Highway Design Comments			
<b>Comments provided by:</b>	Shahzad Mirza		
<b>Date:</b>	Thursday, 01 July 2021		
<b>Planning Application No.</b>	2021/62/92086/W	<b>Case Officer</b>	Victor Grayson
		<b>Highway Officer</b>	-
		<b>Applicant:</b>	Redrow Homes Yorkshire
<b>Planning Application Details:</b>	<ul style="list-style-type: none"> <li>Land at, Bradley Villa Farm, Bradley Road, Bradley, Huddersfield, HD2 2JX</li> </ul>		
<b>Reviewed Drawing Nos.</b>	<ul style="list-style-type: none"> <li>BVF-16-02-03_ Proposed Site Layout</li> <li>BVF-16-02-04_ Proposed Materials Plan</li> <li>BVF-16-02-05_ Proposed Boundary Treatment Plan</li> </ul>

- i. Planning application for land at Bradley Villa Farm, Bradley Road, Bradley, Huddersfield, HD2 2JX for the erection of 270 residential dwellings and associated infrastructure and access;

INSET: A641 BRADFORD ROAD SHARED FOOTWAY/CYCLEWAY
SCALE 1:250

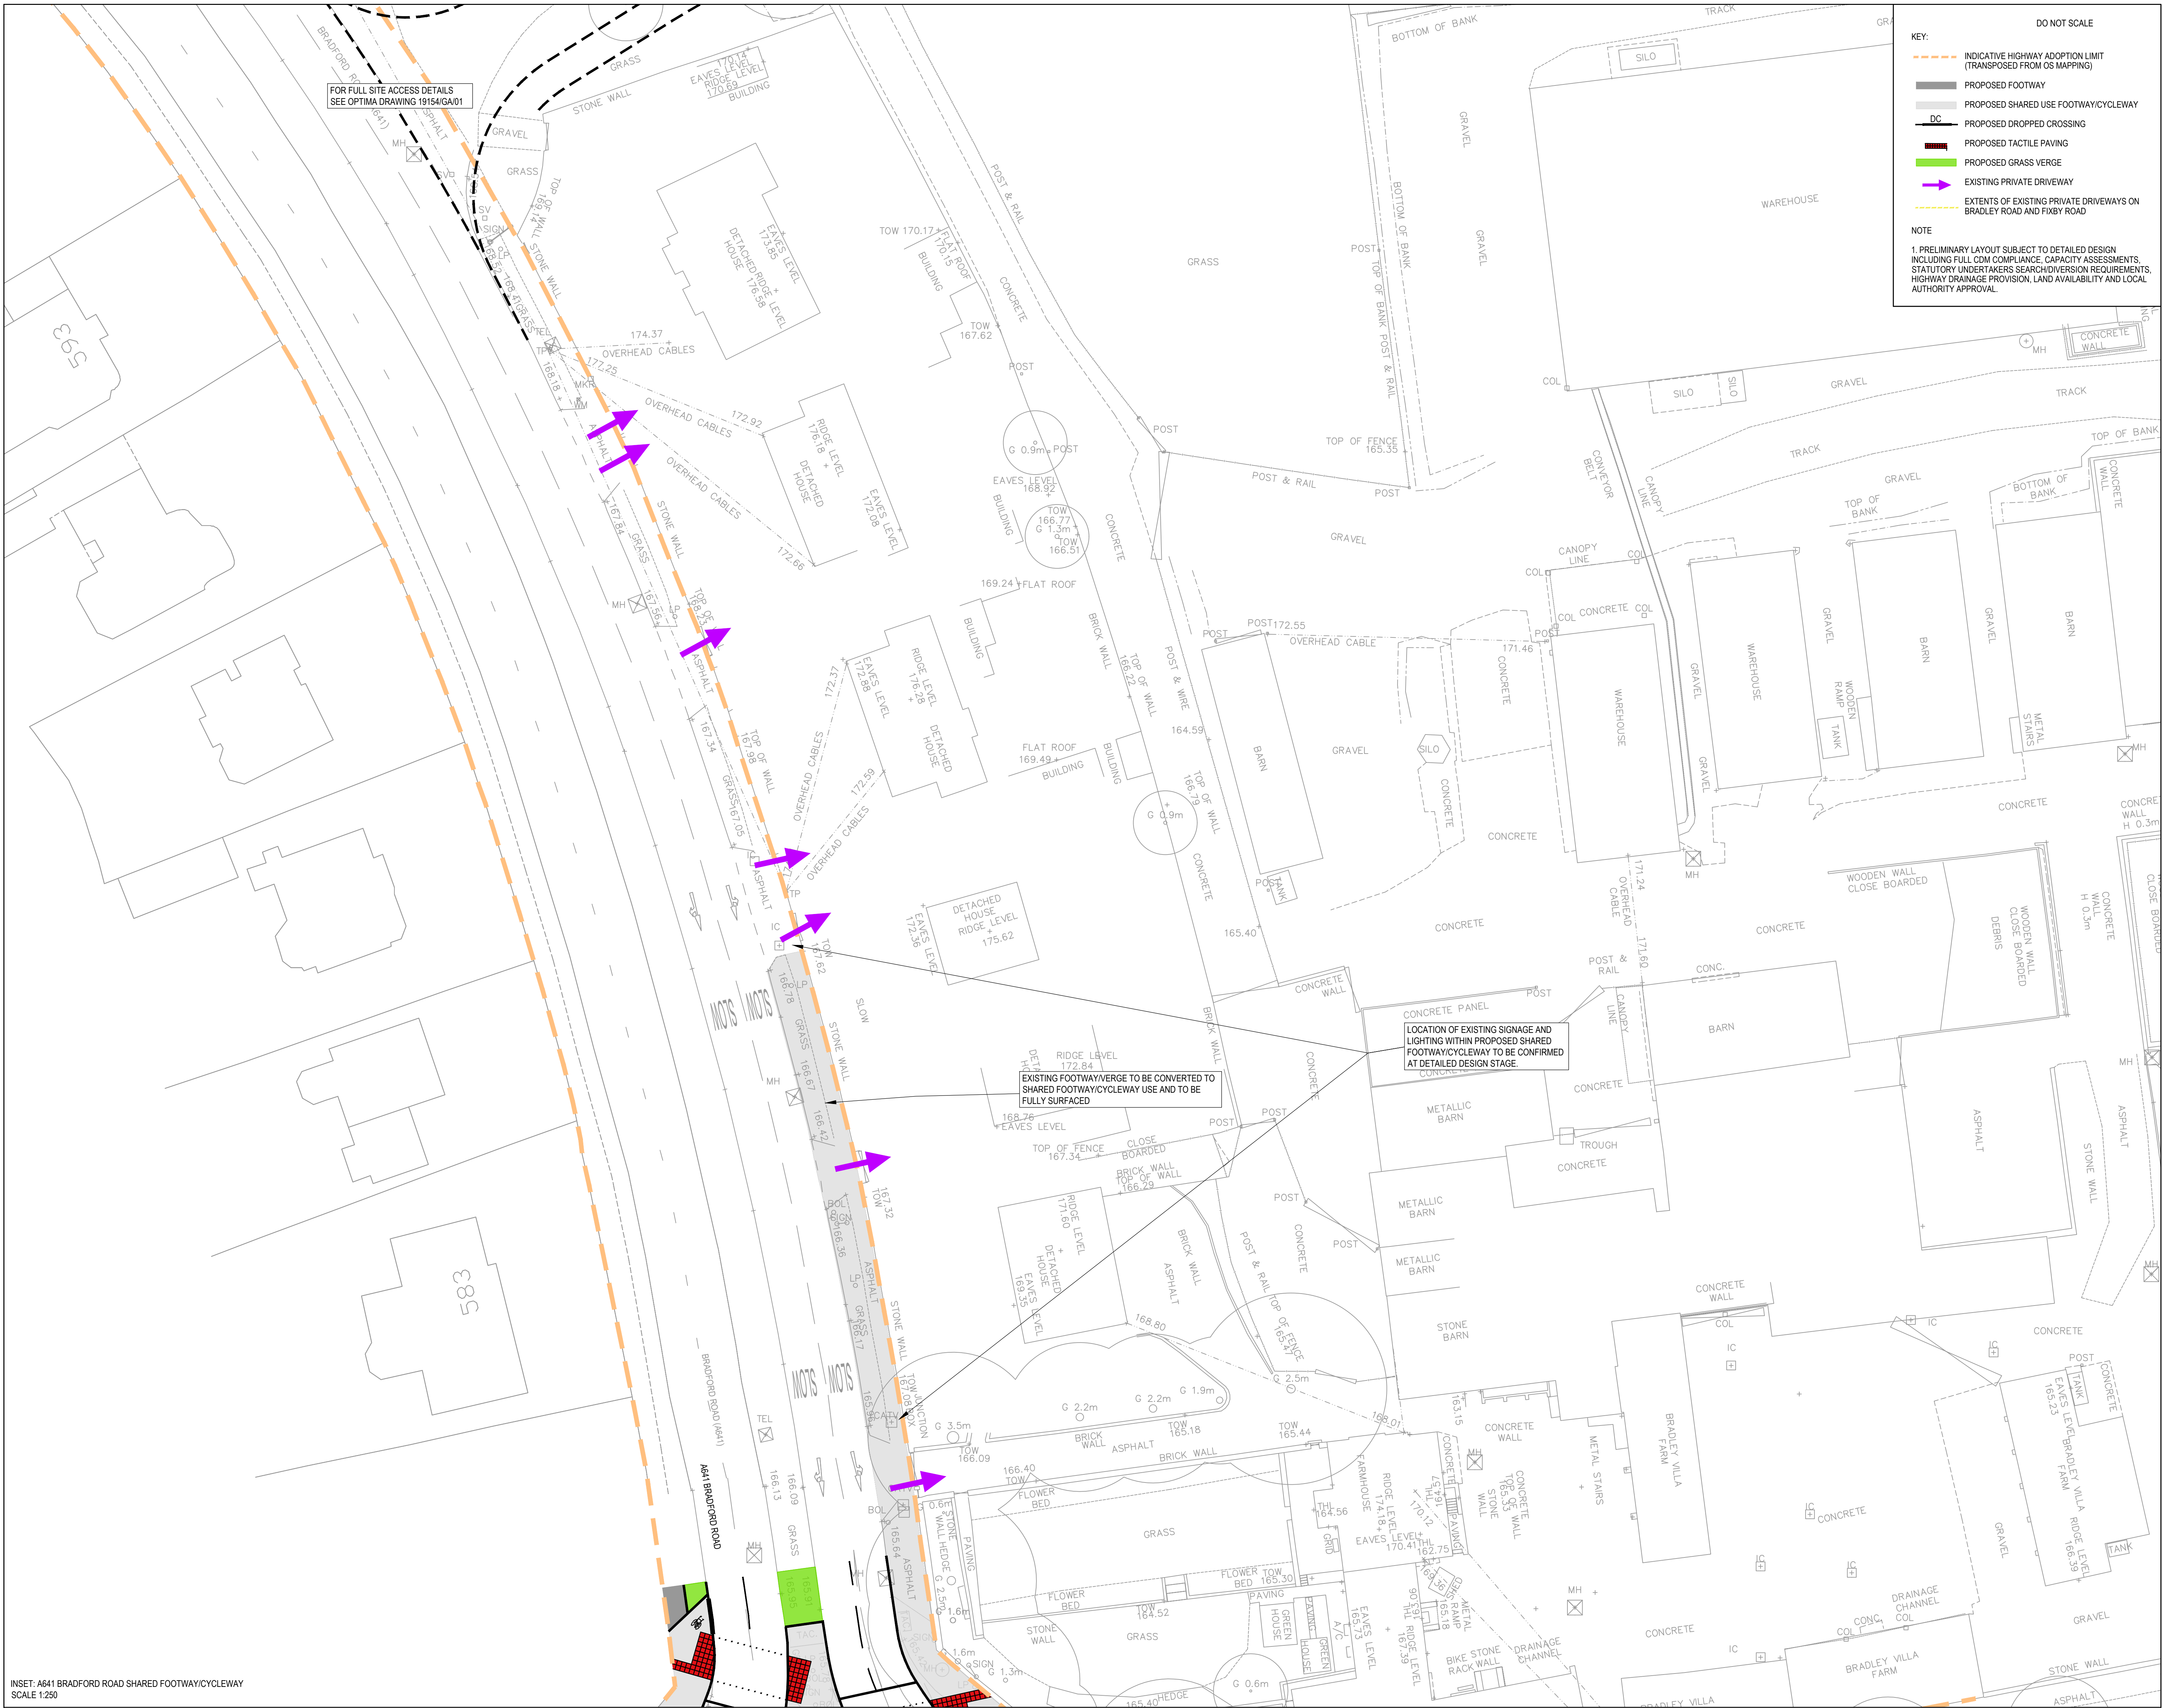
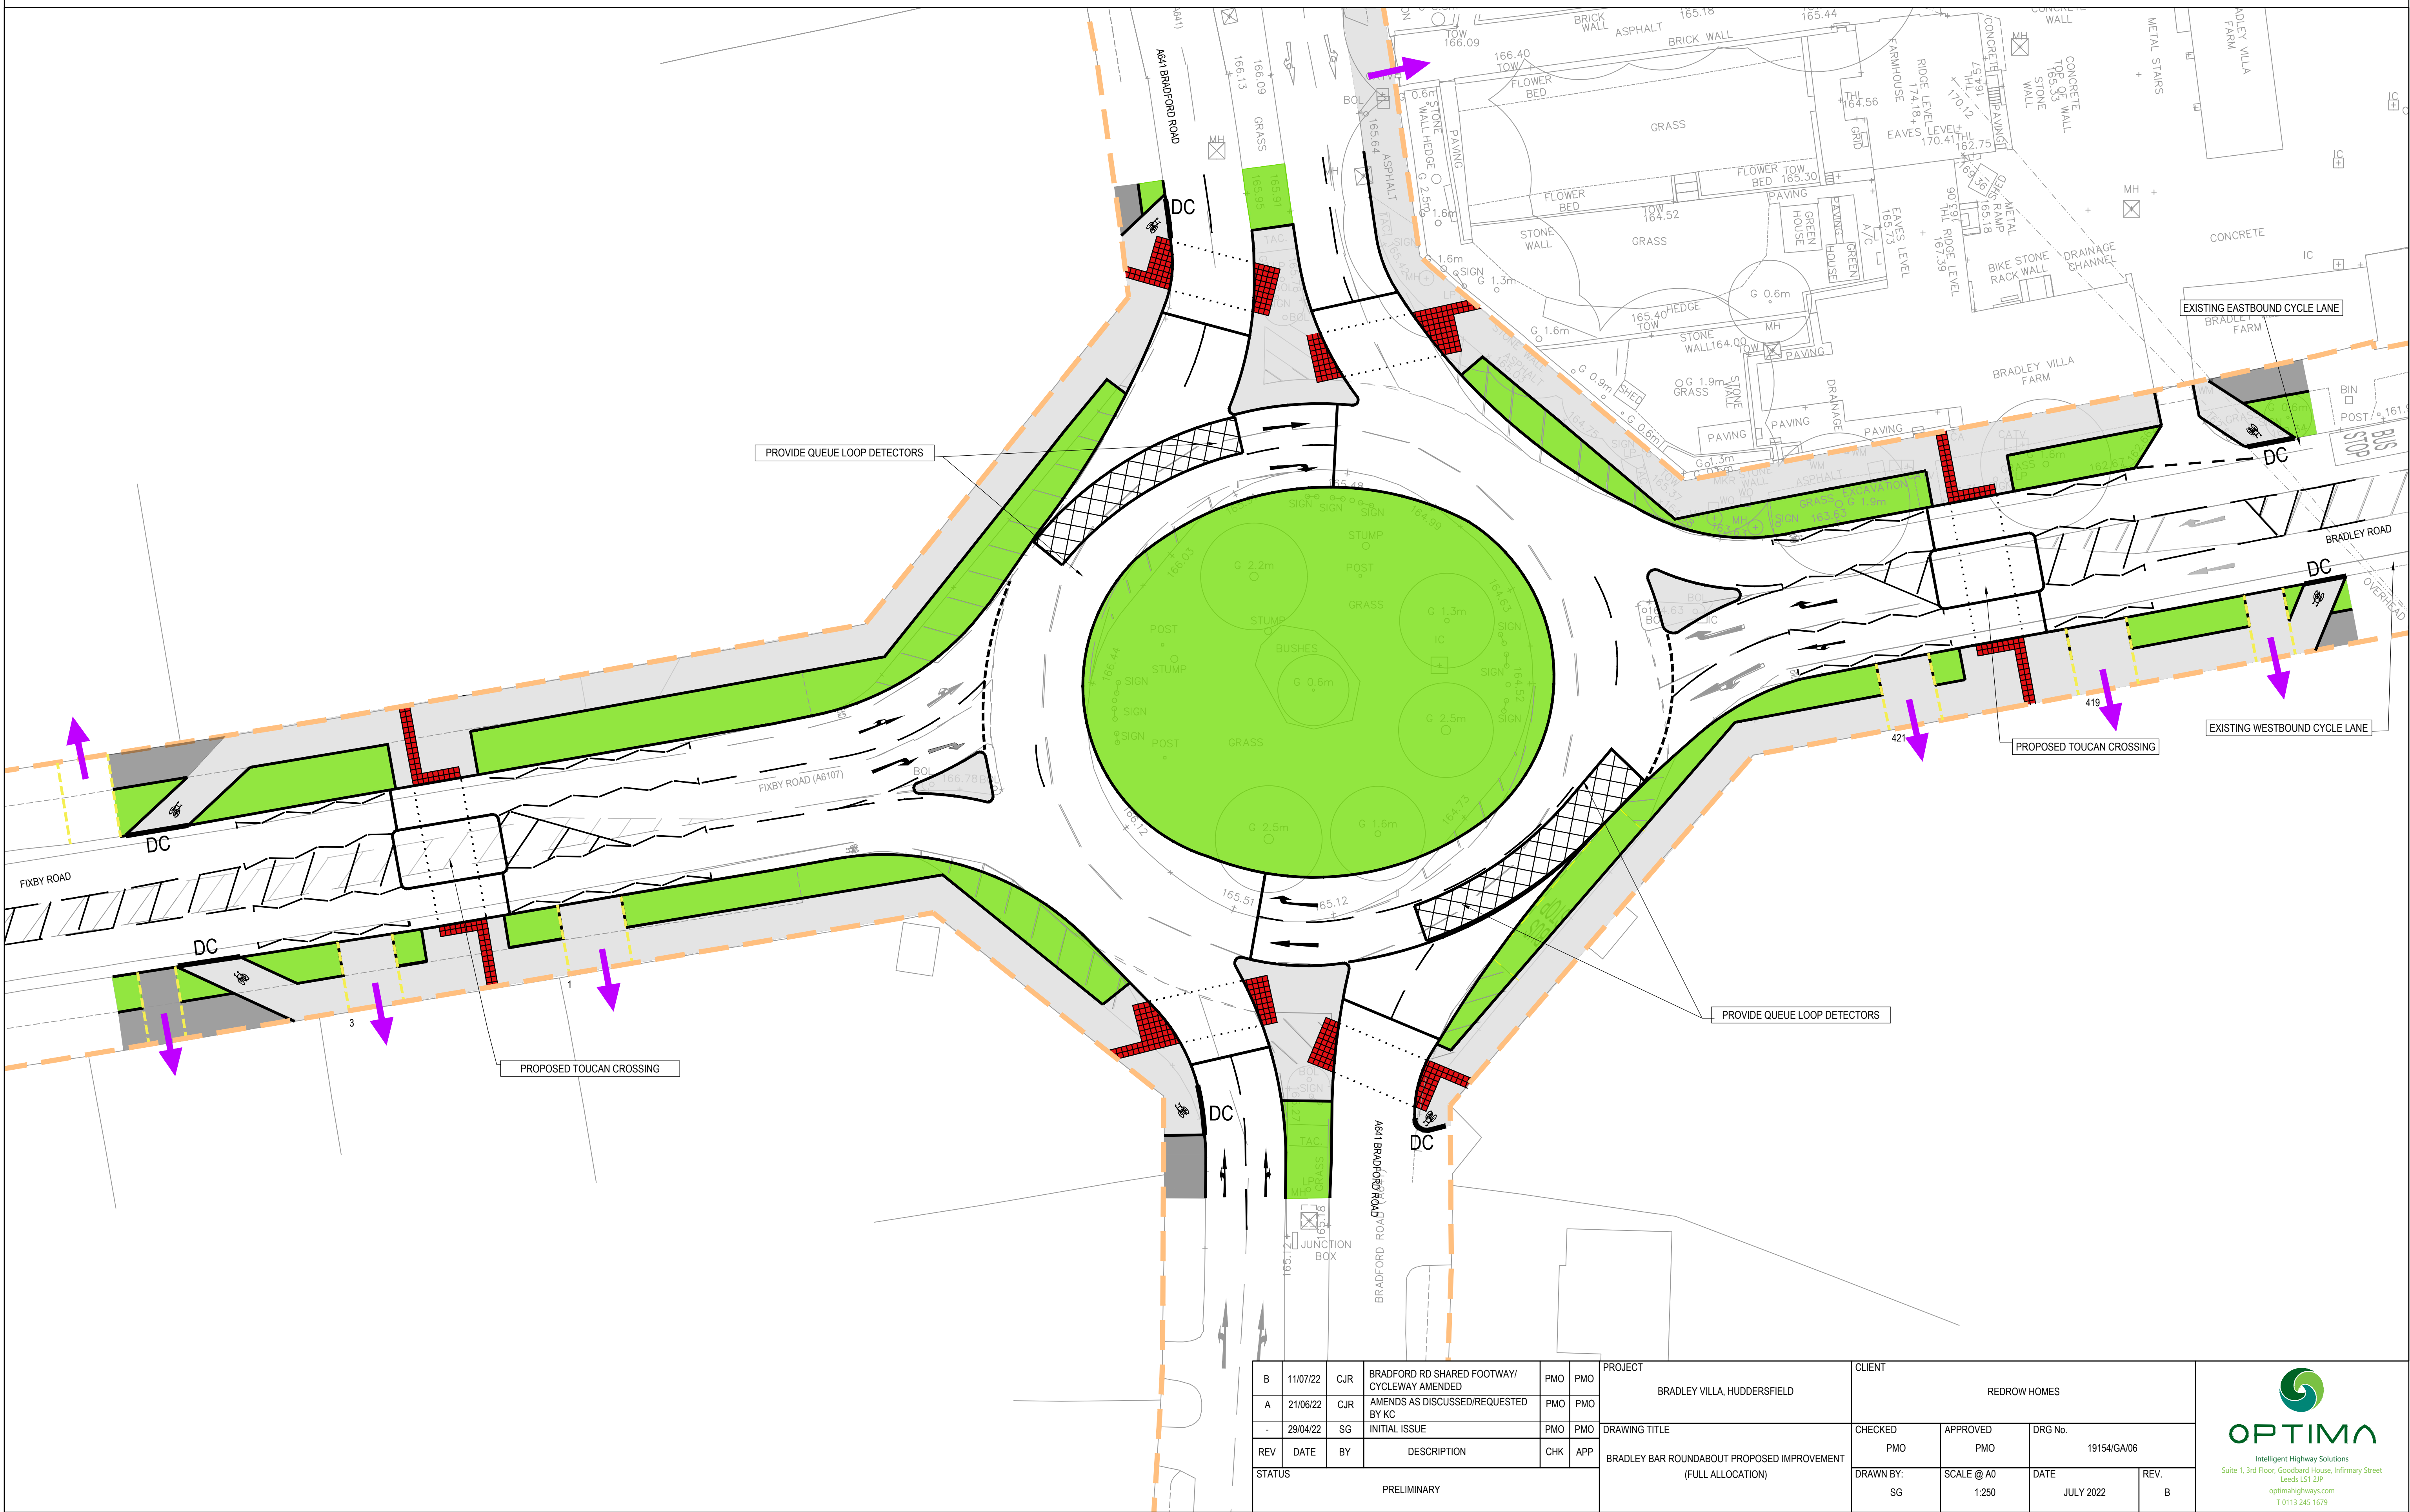
- vi.** Any proposed combined cycle route will need to be 3m wide. There seems to be no provision for cyclist within the development- proposals need to be amended to accommodate minimum requirements in accordance with LTN 1/20 Cycle Infrastructure Design.
